**From:** [REDACTED]  
**Sent:** 29 April 2018 12:12  
**To:** Planning  
**Subject:** Planning application AW/71/18/HH - OBJECTION - FAO Simon Davis  
**Importance:** High

Re : Planning Application AW/71/18/HH– Objections – Queenslawn, 36 Kingsway, Aldwick

As residents of the Drive and co-owners of the verge in Kingsway and Queensway, we wish to object to matters included in this application which would have a detrimental effect on the appearance of this part of the Craigweil House Conservation Area, and the safety of residents and other visitors to the Estate.

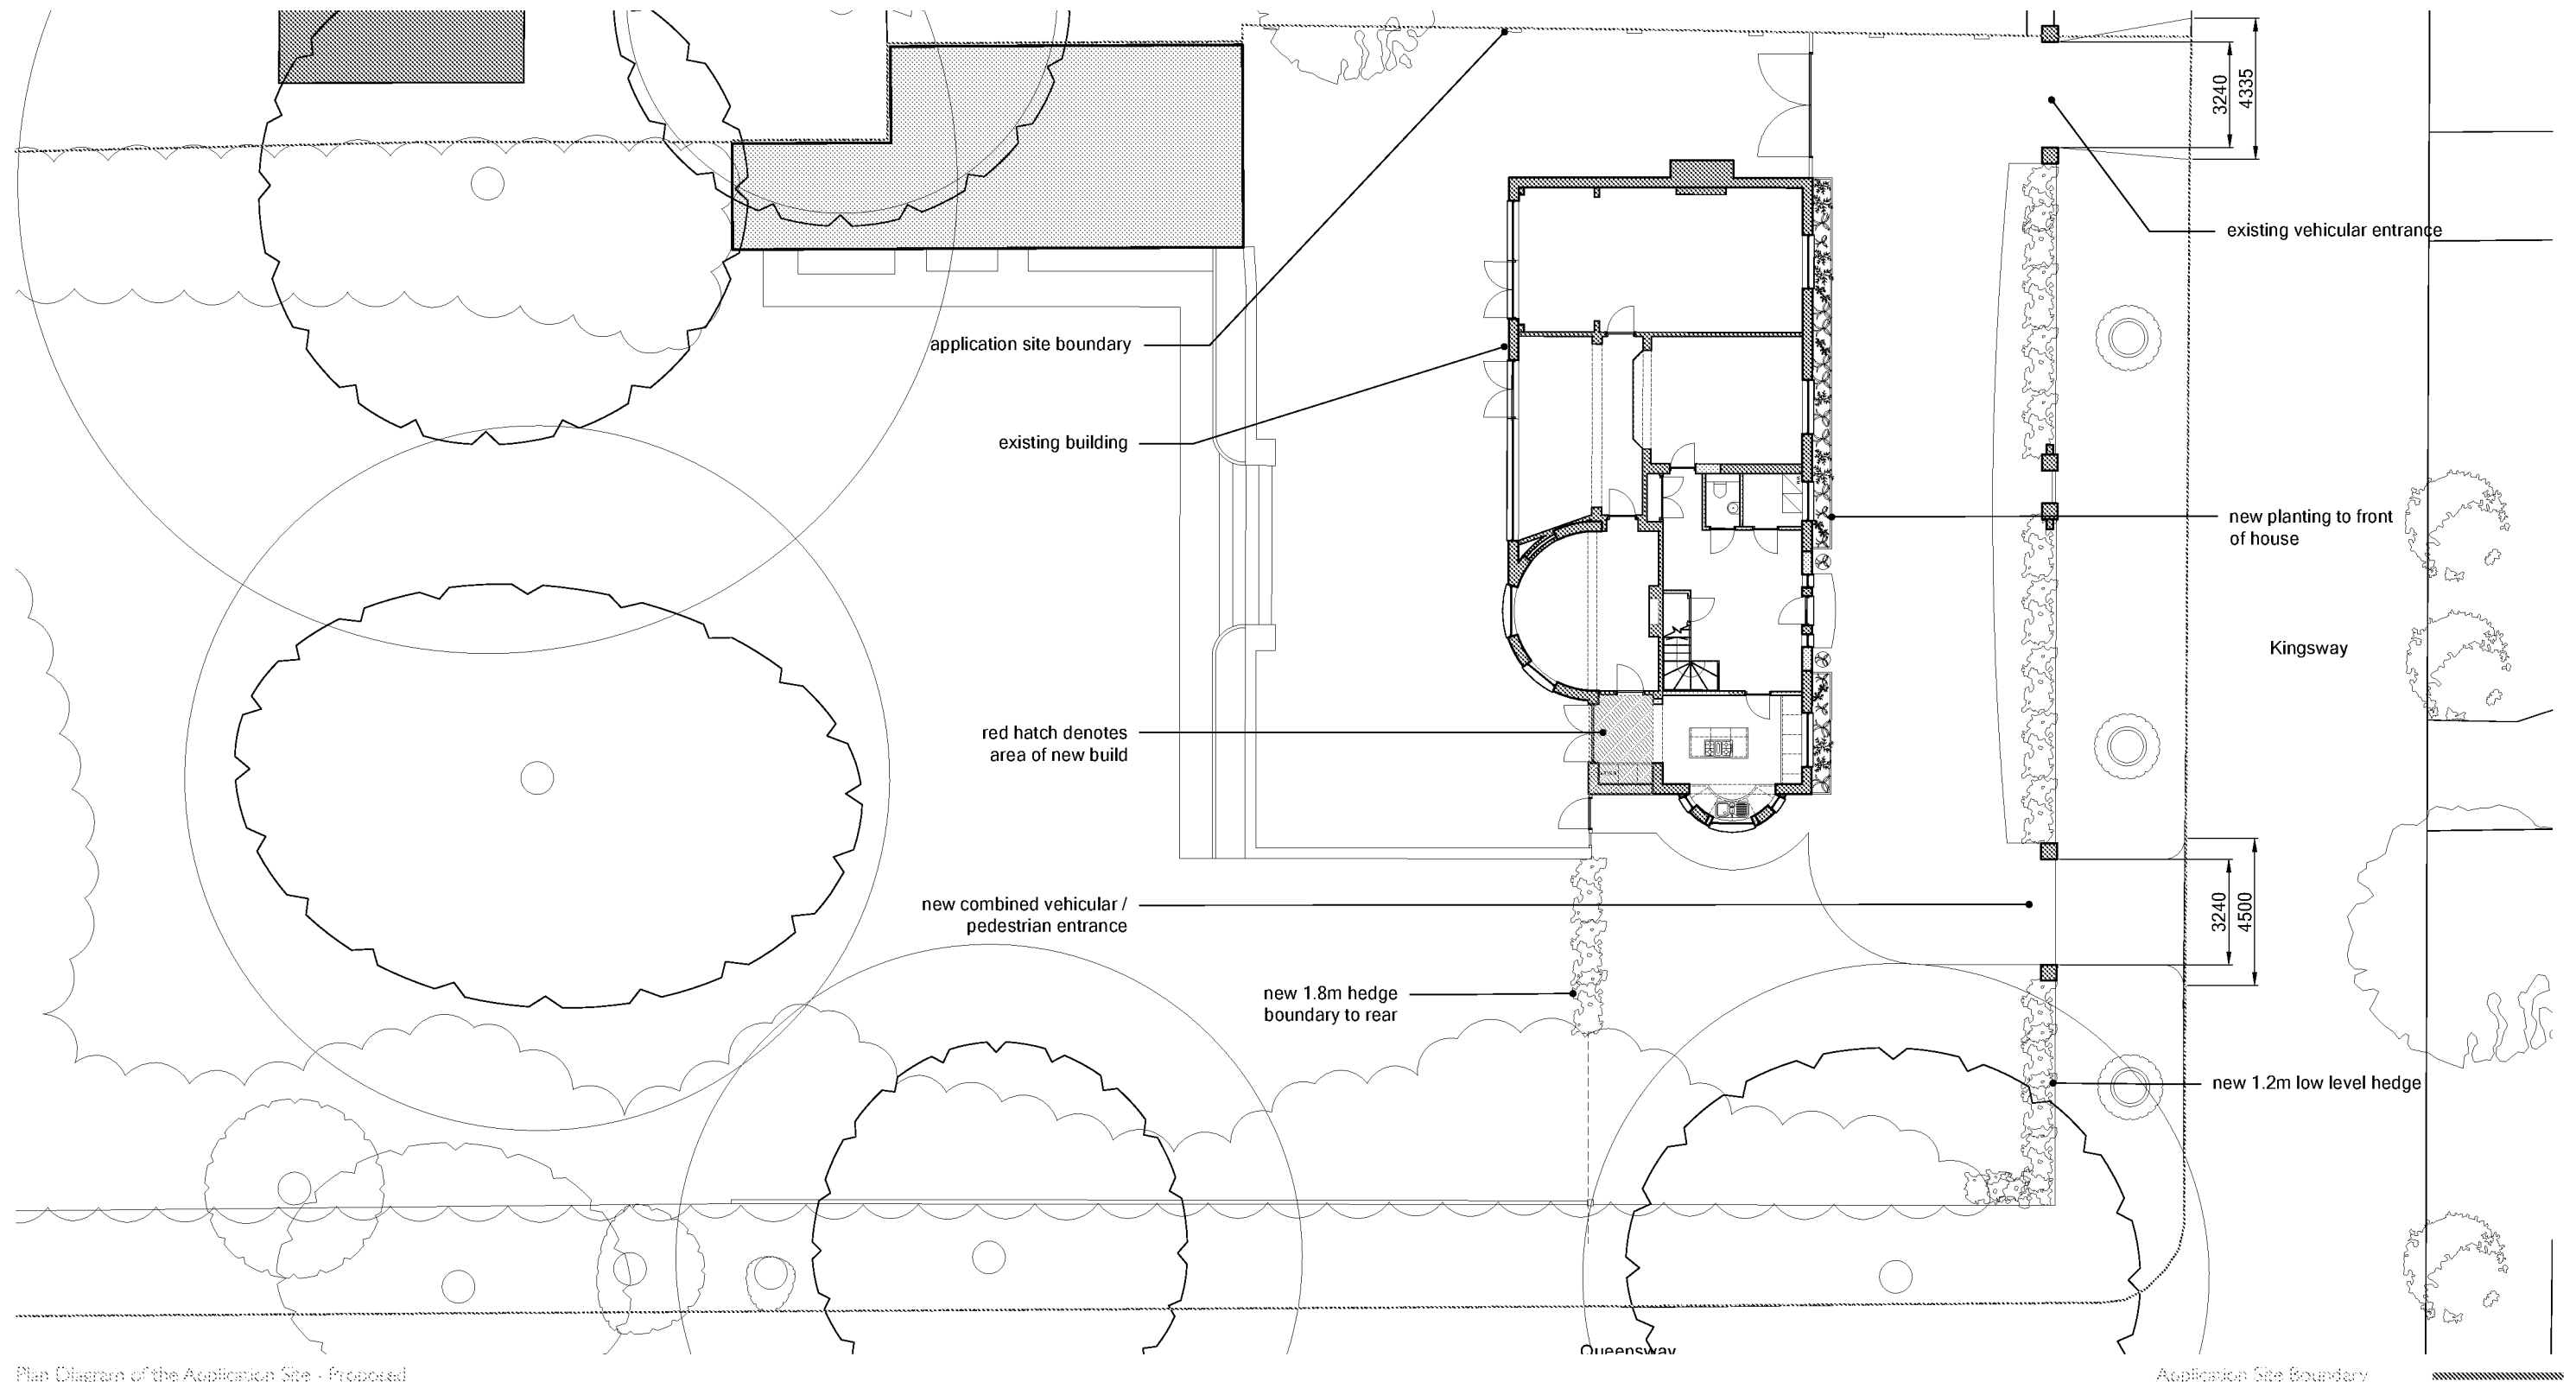
Additional access as proposed, would disrupt the street scene and would spoil the amenity of the area.

- (2) The question of residents' safety seems not to have been considered. Quite apart from the visual clutter of two vehicle access points, the proposal is to position the additional vehicle access only 10m from the corner of Kingsway/Queensway, with consequent danger to pedestrians and drivers using both roadways.
